From: Craig Robert <rcraig@penrithcity.nsw.gov.au>
To: "fiona.gibson@planning.nsw.gov.au" <fiona.gibson@planning.nsw.gov.au>
Date: 3/04/2014 11:48 AM
Subject: Modification Application - Stage 3B, North Penrith Defence Suite (SSD 5349 MOD 1)
CC: Wood Peter <PWood@penrithcity.nsw.gov.au>, McMurtrie Amanda
<amcmurtrie@penrithcity.nsw.gov.au>

NORTH PENRITH (THORNTON):
STAGE 3B - PLAN OF PROPOSED SUBDIVISION OF
LOT 1198 DP1171491

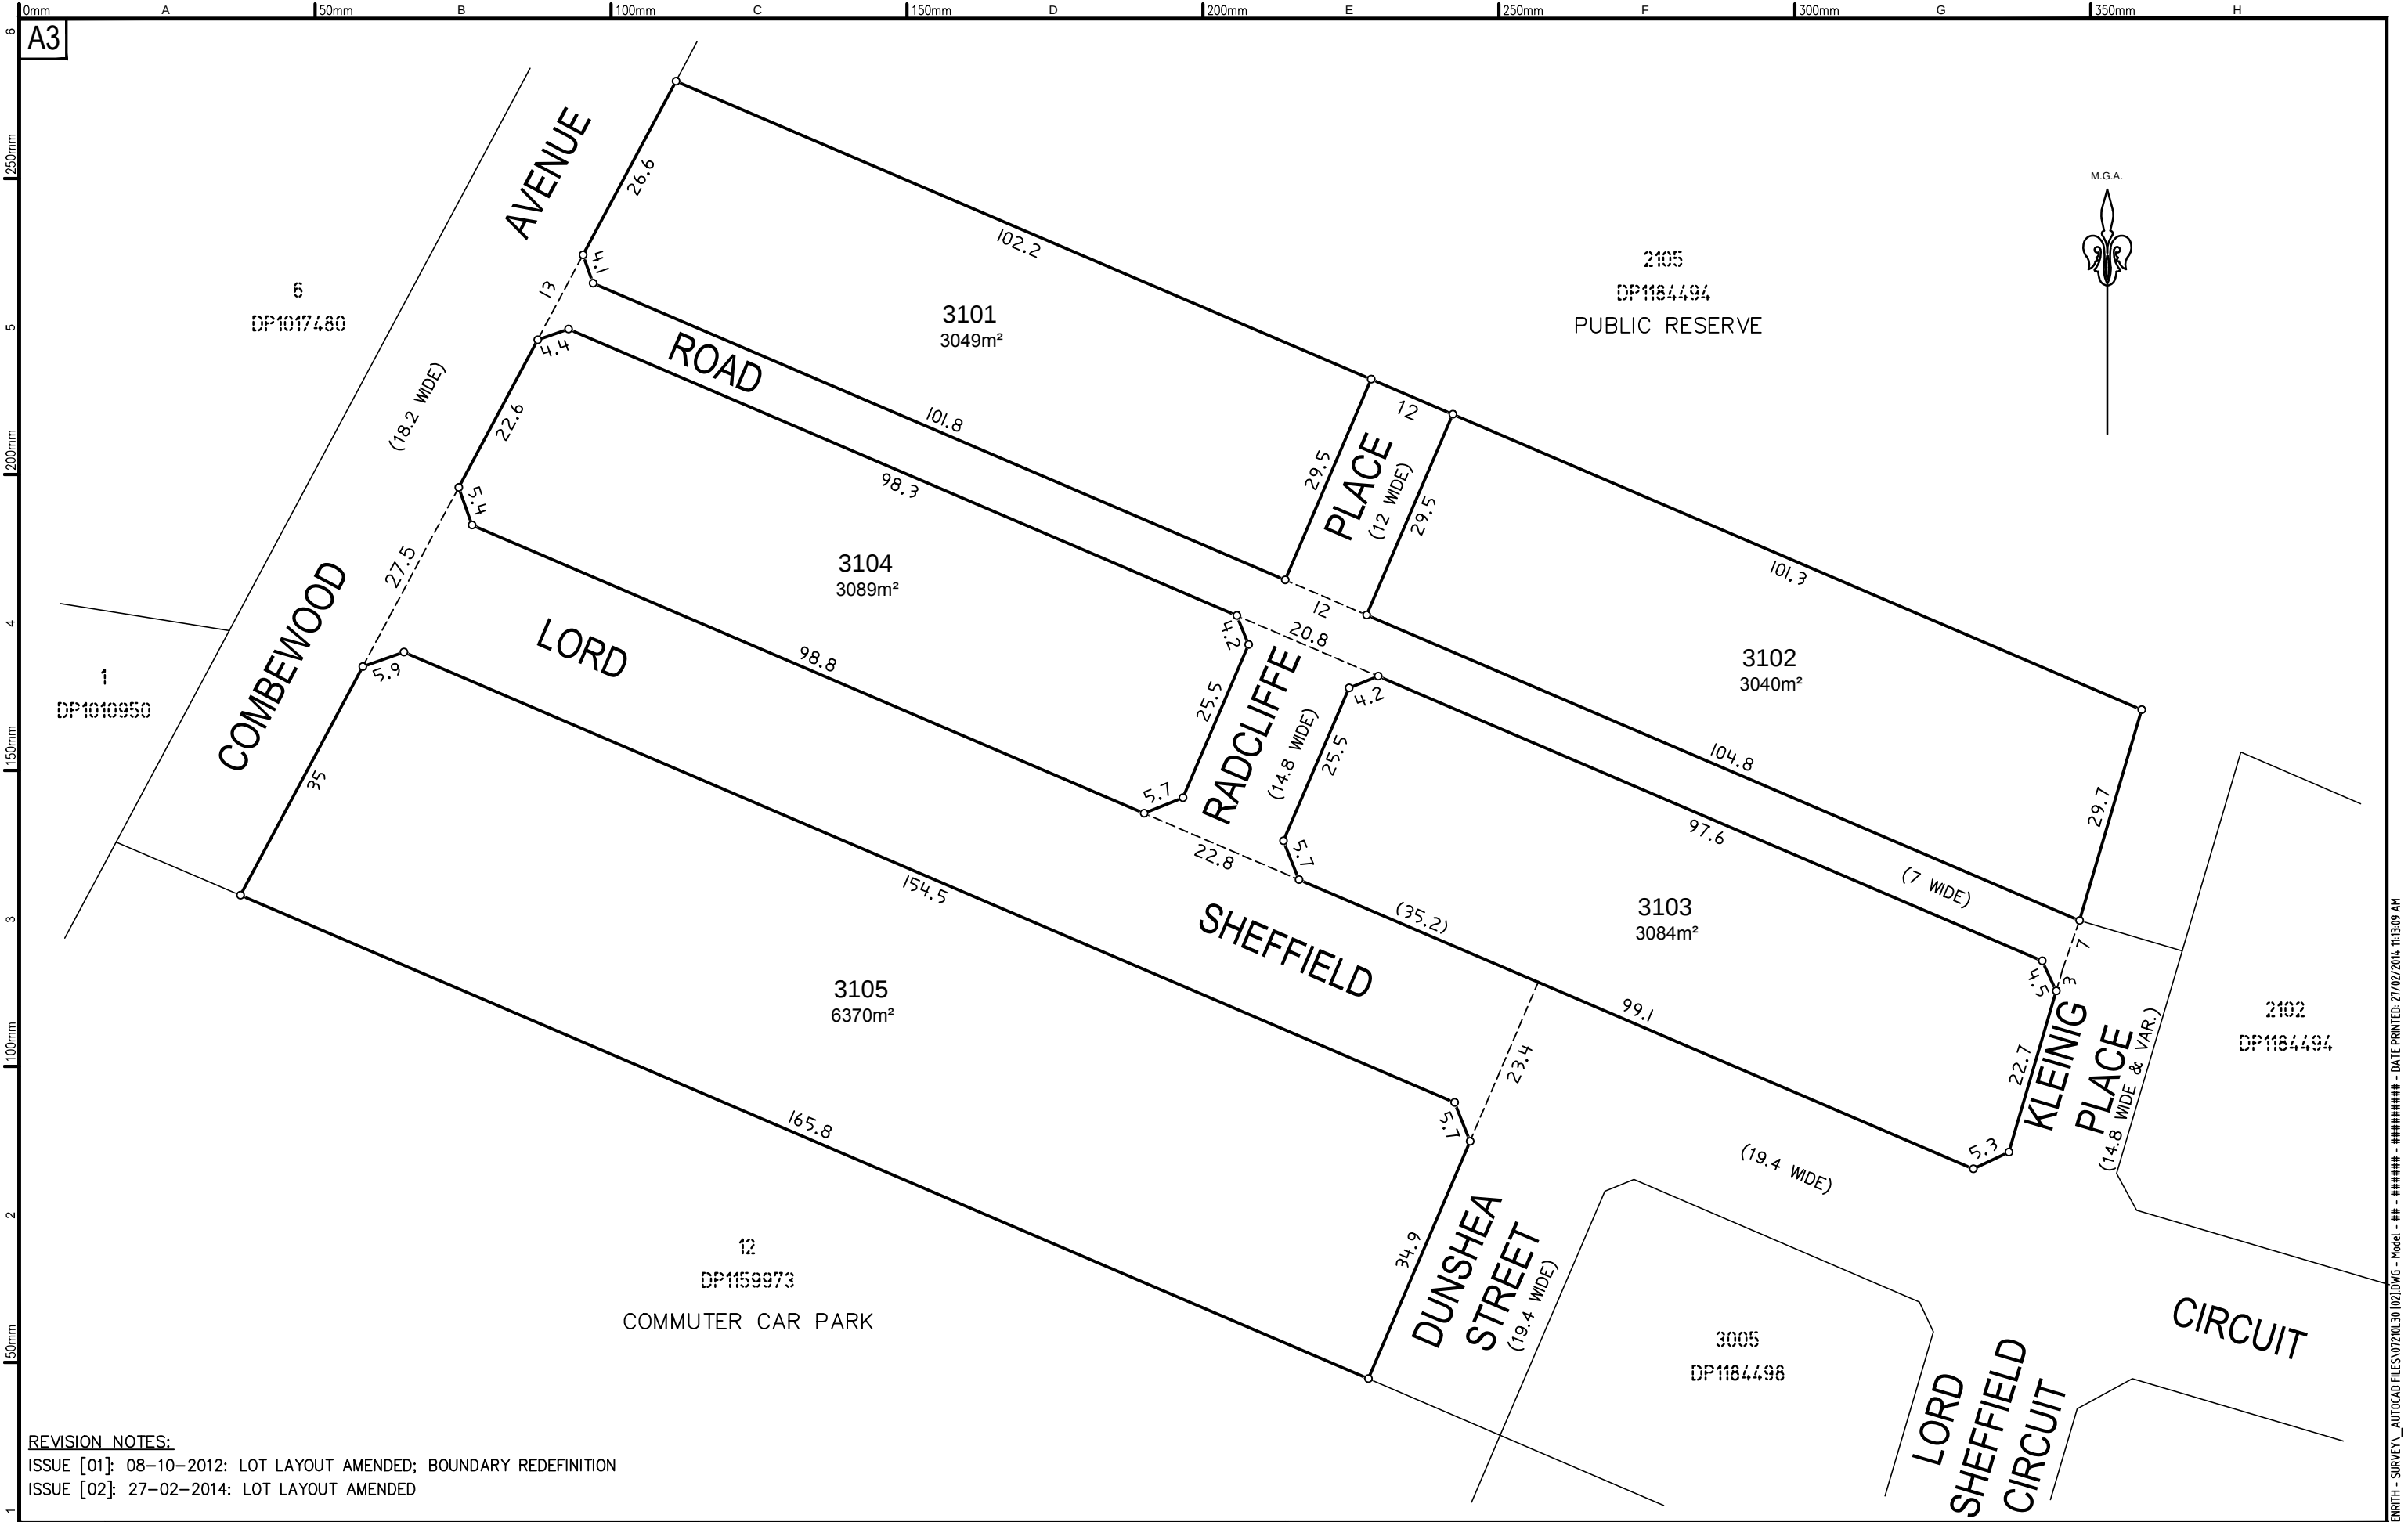
It is noted that proposed Lots 3101 to 3105 are located within the area nominated as the "opportunity site" in the North Penrith Design Guidelines (Figure 14). It is also noted that proposed Lots 3103 to 3105 are nominated as "apartment sites" in the Design Guidelines (Figure 15).

The JBA letter dated 10 March 2014 indicates that the intention is to deliver rear-loaded terrace housing (presumably 2 storeys in height) on proposed Lots 3101 to 3104. Terrace housing on these sites is considered to represent an underutilisation of the land where higher density residential development (and some non-residential uses where appropriate) should be pursued in such close proximity to the Penrith City Centre and public transport links.

The proposed laneway and subdivision scheme in addition to Urban Growth's intentions as outlined in the JBA letter will impinge on future opportunities to achieve the intent of the Design Guidelines in relation to the opportunity site, apartment sites and canal edge lots. Further information should be sought from Urban Growth demonstrating the revised subdivision scheme will not preclude the achievement of these objectives.

NORTH PENRITH
STAGE 3B
SITE LAYOUT PLAN
& LEGEND

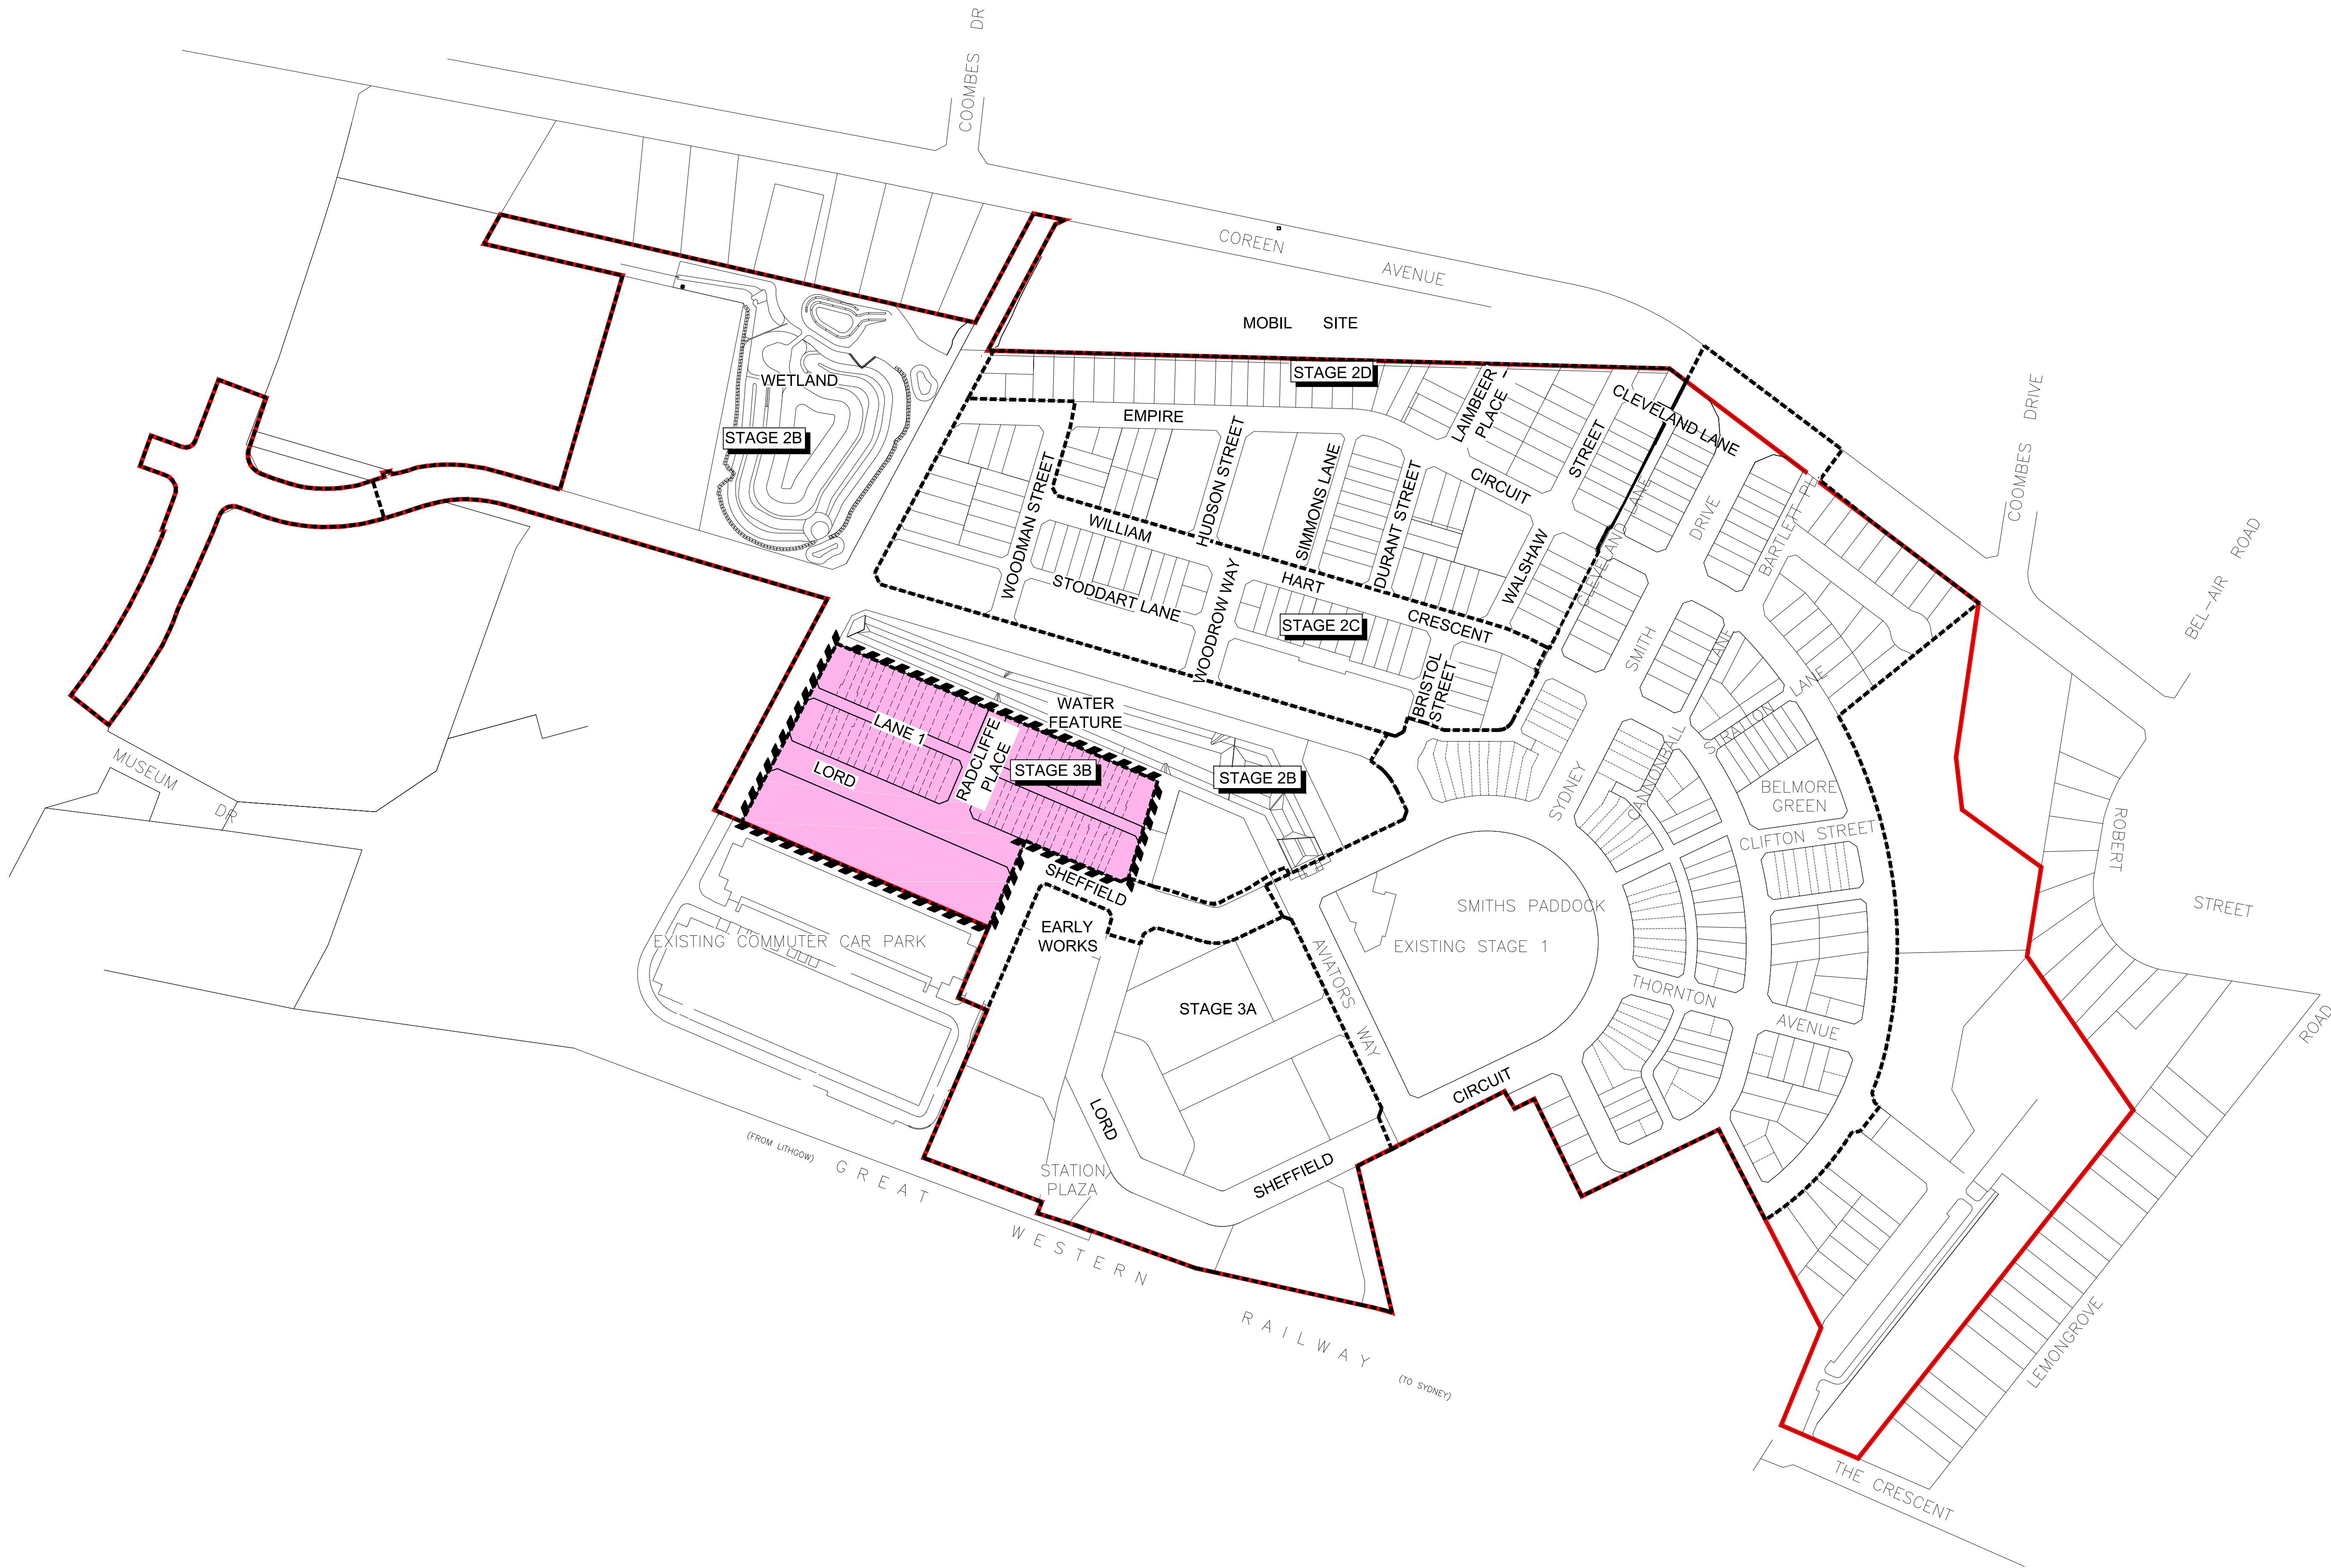
While it is acknowledged that the location of the proposed laneway is consistent with the North Penrith Concept Plan, the provisions of the Design Guidelines in relation to the opportunity site and apartment sites need to be given due consideration. Due consideration also needs to be given to the minimum 3 storey building height which is "strongly encouraged" in the Design Guidelines for the "canal edge lots" (i.e. proposed Lots 3101 and 3102).
